From: Amanda Scholes on behalf of Planning.Responses
Sent: 07 December 2017 08:41
To: Planning Scanning
Subject: FW: BE/102/17/OUT Salt Box, Land off Rowan Way, Bersted

Table 7A on page 20 of the Transport Assessment identifies that the proposed development will add 54 trips in the AM peak hour and 58 in the PM peak hour at the A259 / A27 Chichester Bypass (Bognor Road) Roundabout, which already suffers from severe congestion. However, no corresponding capacity assessment has been undertaken in the TA, and thus our advice was for the council to determine and, as appropriate, negotiate any proportionate contribution from this application towards the improvements at the Bognor Road Roundabout on the A27 Chichester Bypass, with the development being a Strategic Employment Site.

**REFERENCE FLOWS (ADJUSTED) :
A259/A27 CHICHESTER BYPASS ROUNDABOUT**

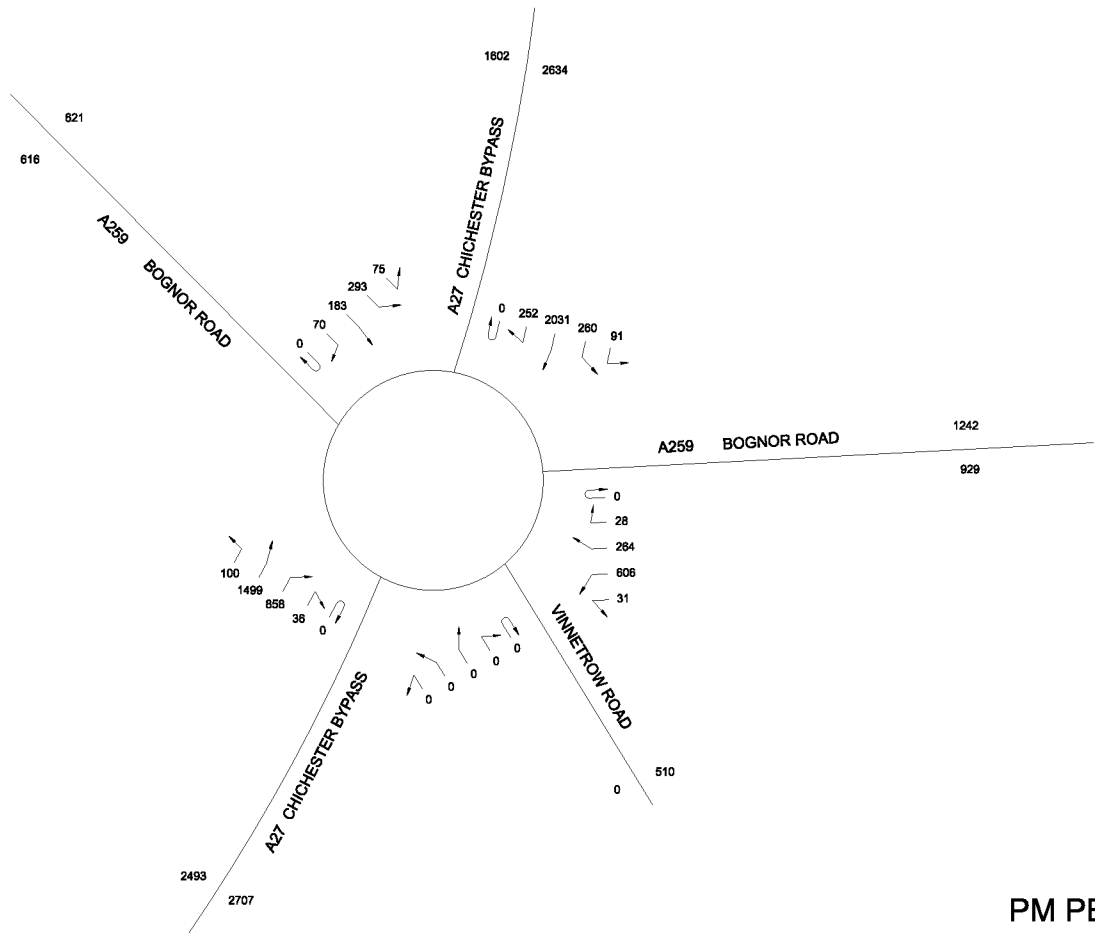
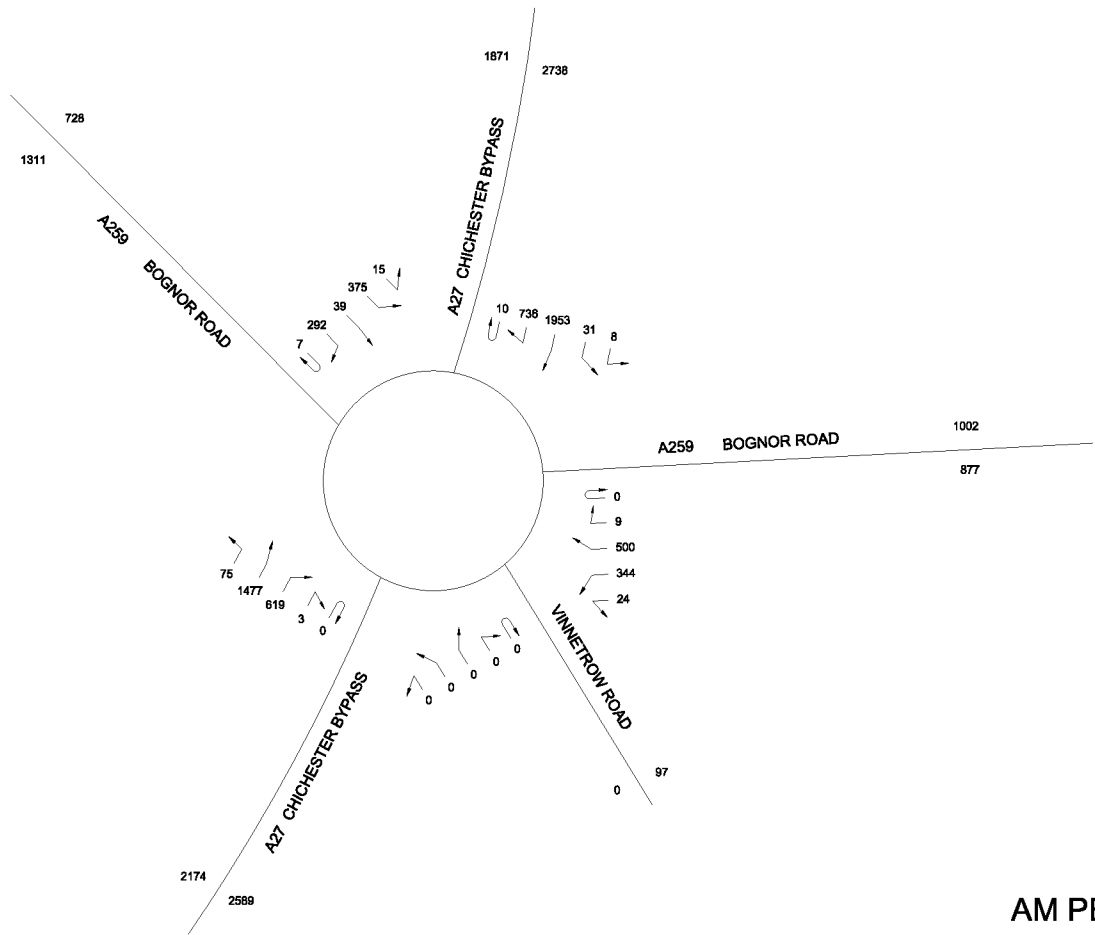
- 1) Undertake a capacity assessment of the junction and propose their own bespoke costed mitigation scheme, taking account of all others already agreed; or
- 2) Contribute towards the Local Plan led cumulative mitigation scheme as identified in Systra's "Enterprise Bognor Regis Transport Review 2017 Report", which is costed at £915,000.

If the latter approach is adopted, we would suggest a contribution in the region of £250,000 to be secured prior to the site being brought into use.
